1000, LLC
7190 COLE VIEW, CBP LOT 12
EL PASO COUNTY, CO

DETAILS AND NOTES

Markup Summary

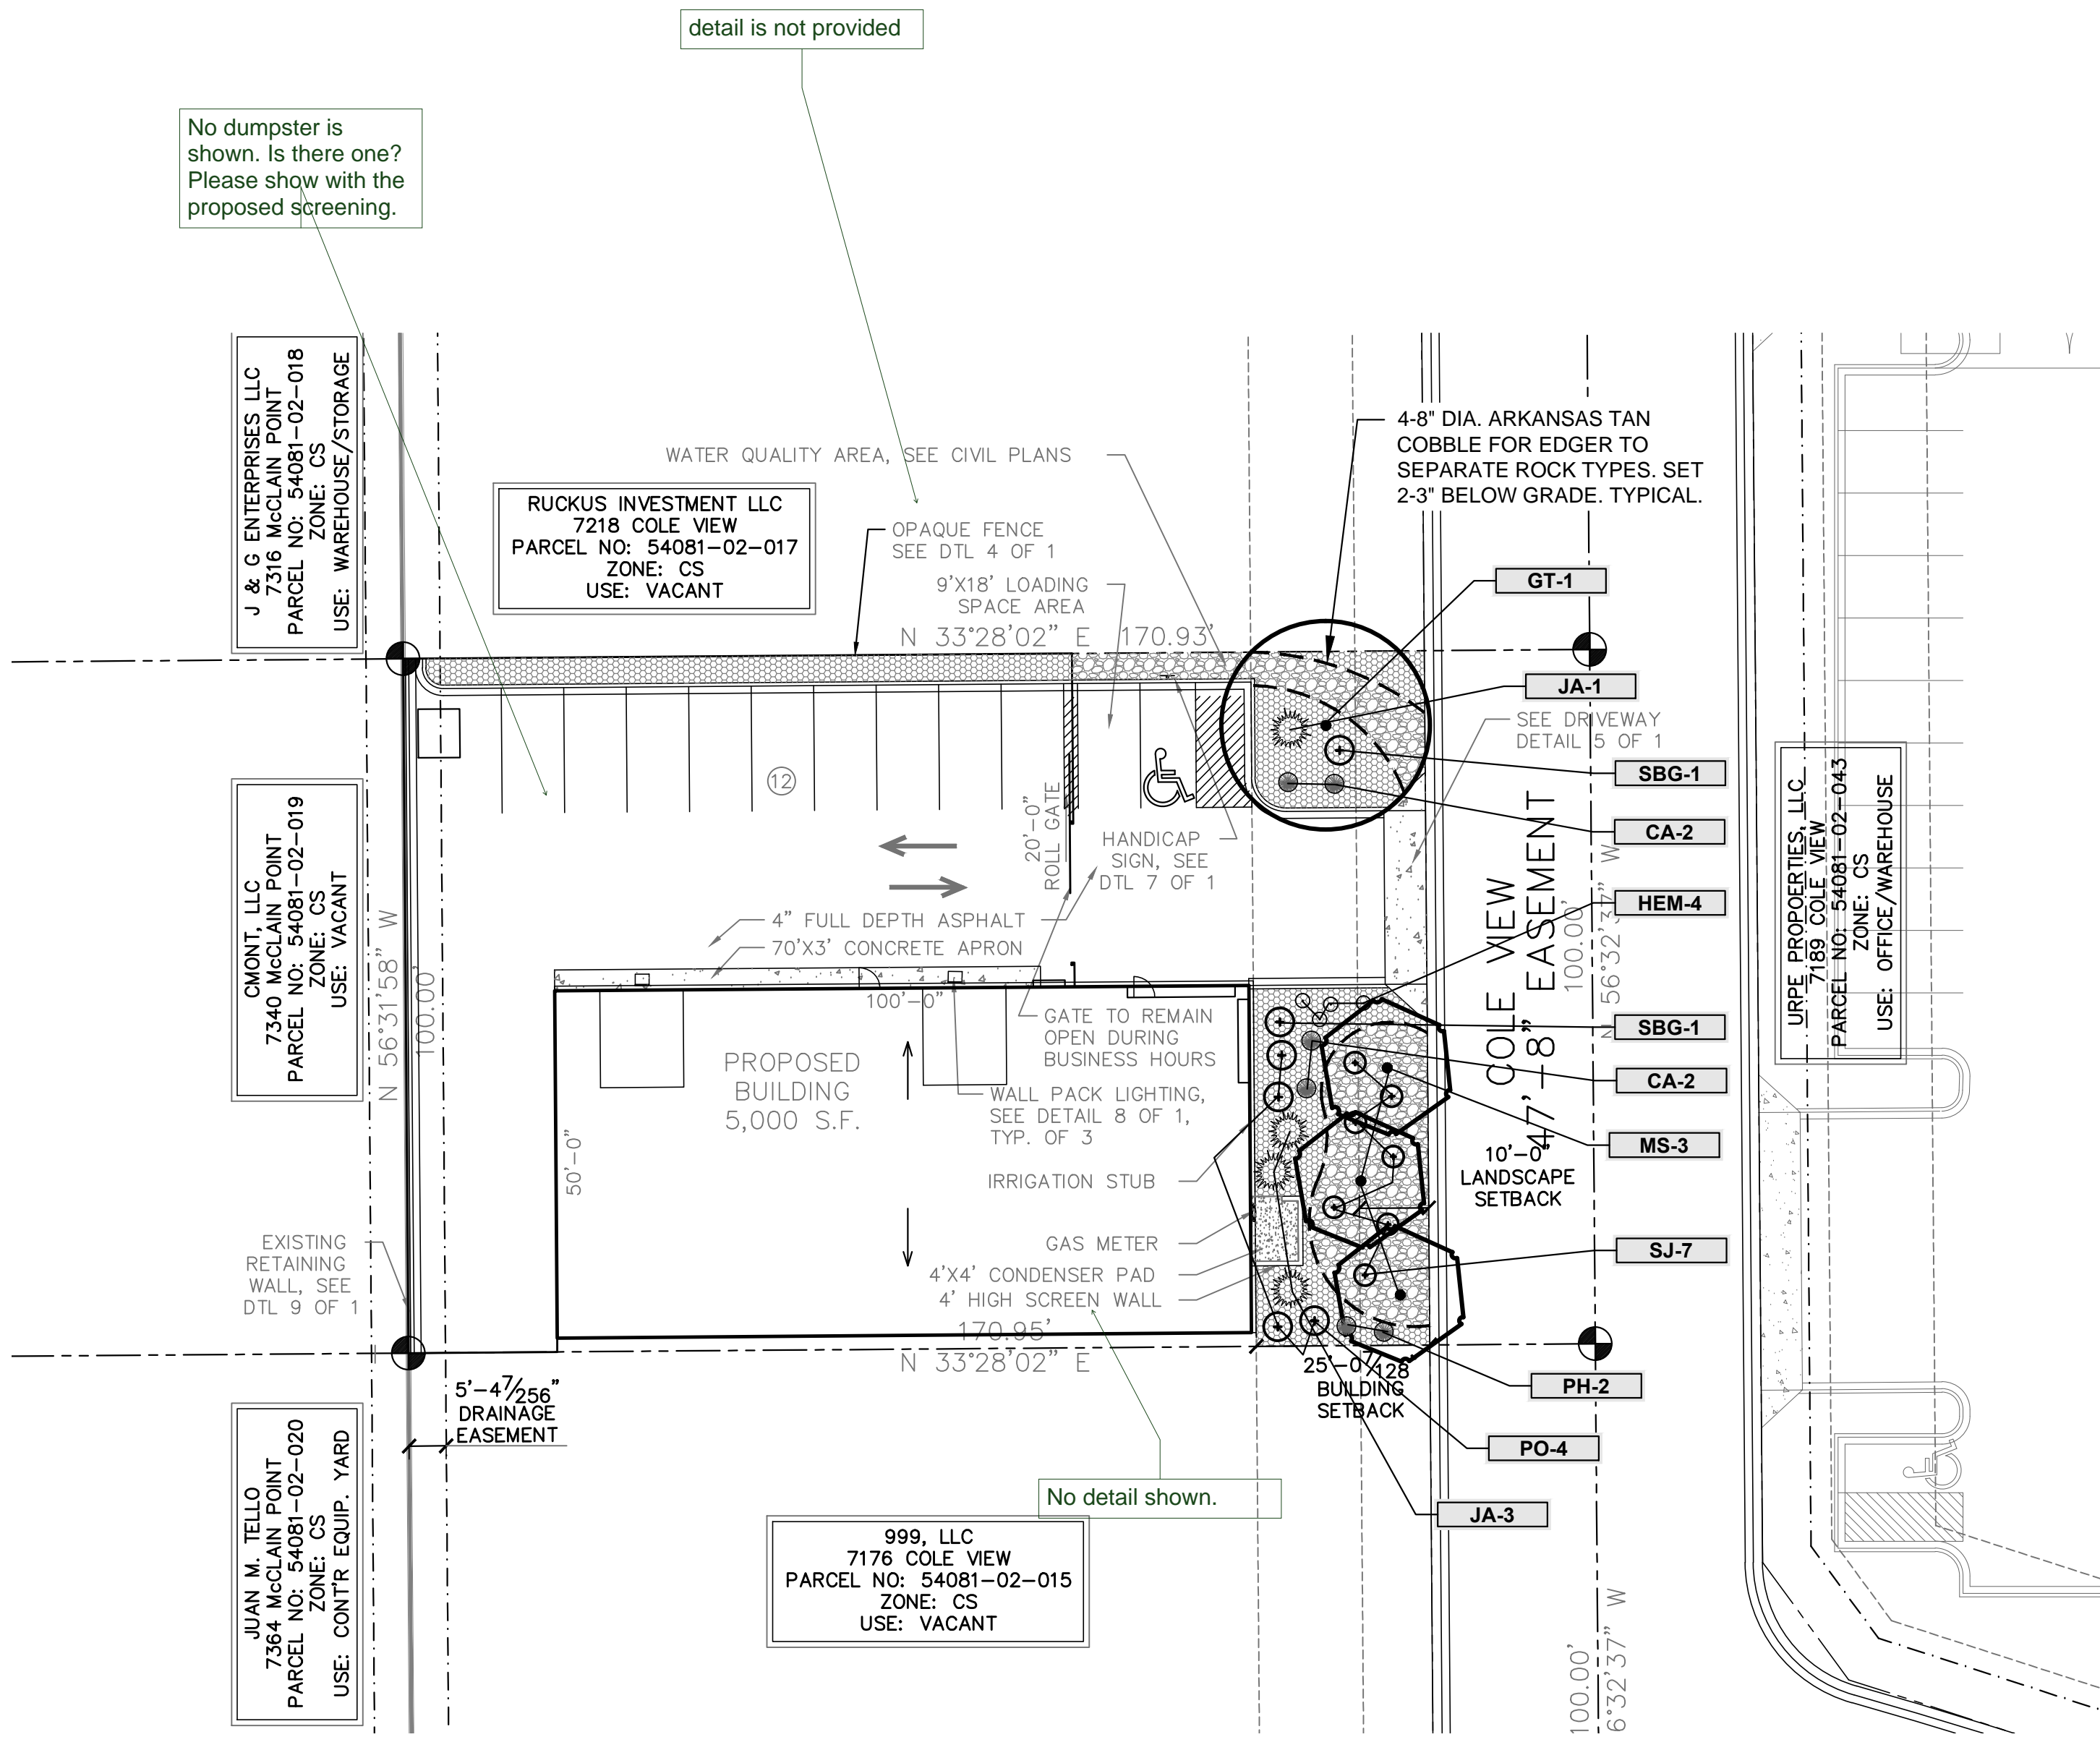
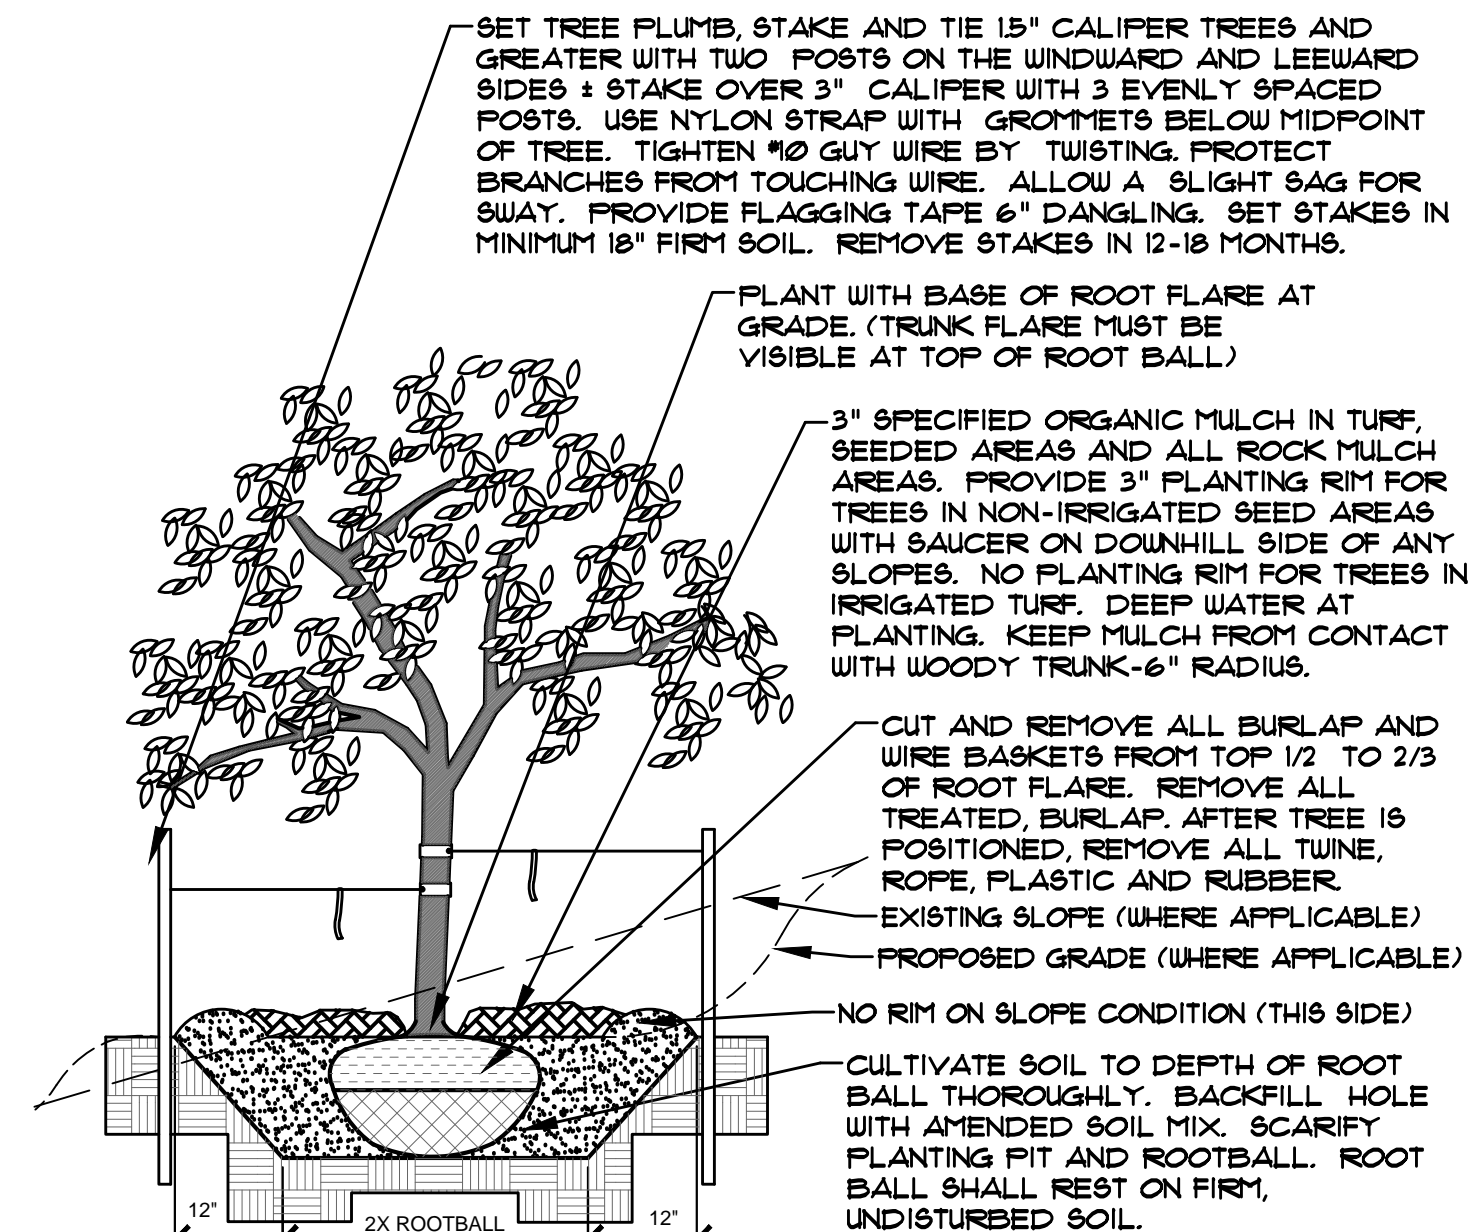
screen wall detail is not included.
